Subject: OBJECTION to the Proposed Development Land at Chandlers BMW, Water Lane, Angmering, BN16 4EH (A/45/19/PL)

I would like to register my **OBJECTION** to the Planning Application **A/45/19/PL** (Proposed Development Land at Chandlers BMW, Water Lane, Angmering, BN16 4EH) and advise of my reasons below:

Fig 4. Site Layout

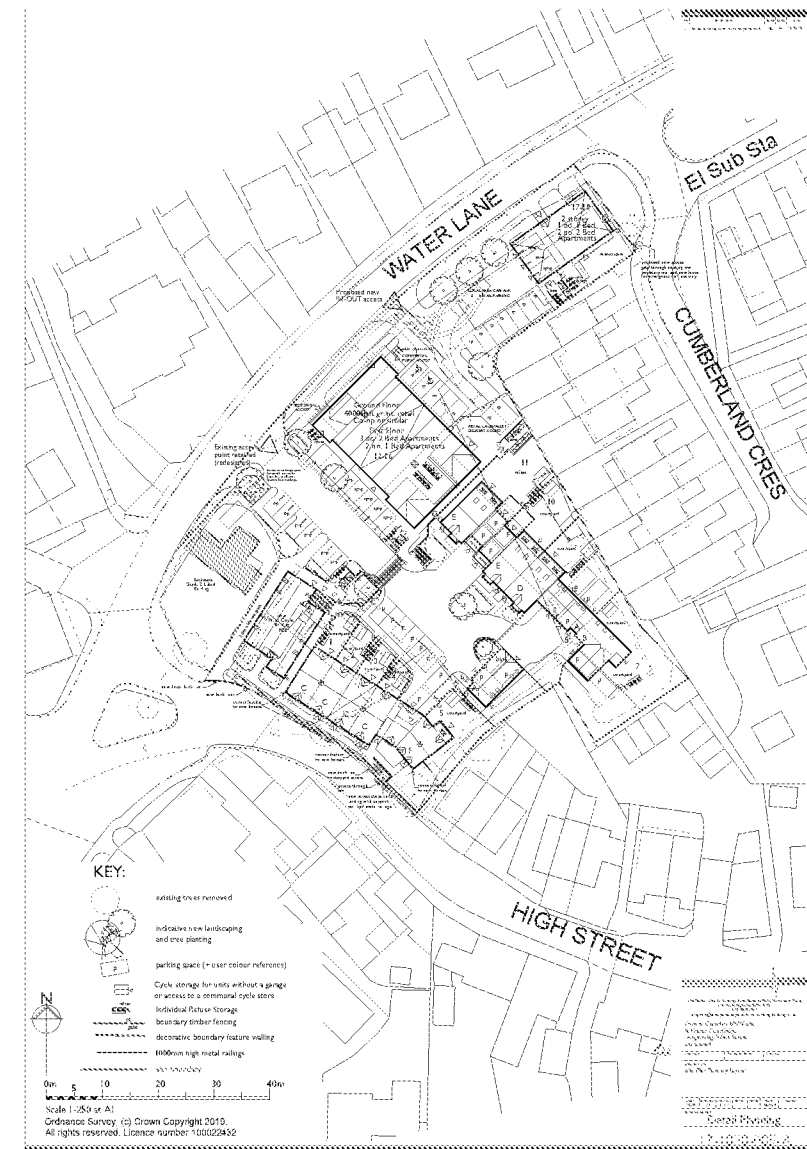
Roofs are out of scale, particularly on Plots 17-19 and Plots 1-6, which should be more in-keeping with the Conservation Area and adjacent Eachways to protect the street character. Roof designs do not currently meet Fig 6.5 in the Neighbourhood Plan. The adjacent buildings have lower ridge heights.

Plots 9, 10 & 11 are particularly out of scale/character as town houses with car ports.

There is no street elevation for Cumberland Crescent but Plots 17-19 look out of scale to the adjacent houses. Roofs are too high and balconies out of character. The building is further forward than the existing single storey car port and will impact sightlines for vehicles exiting Cumberland Road.

Parking for the development goes against the Neighbourhood Plan as there are not many visitor bays for Plots 1-11 and no visitor bays for Plots 12-19. This would also impact Highways safety.

There is a hazard when delivery vehicles reverse, and the designer should eliminate the need for three-point turns. As it stands delivery vehicles are more likely to park on Water Lane pavement to avoid reversing.

Visibility would be poor at the exit closest to the high boundary of Eachways/near the bend in Water Lane.
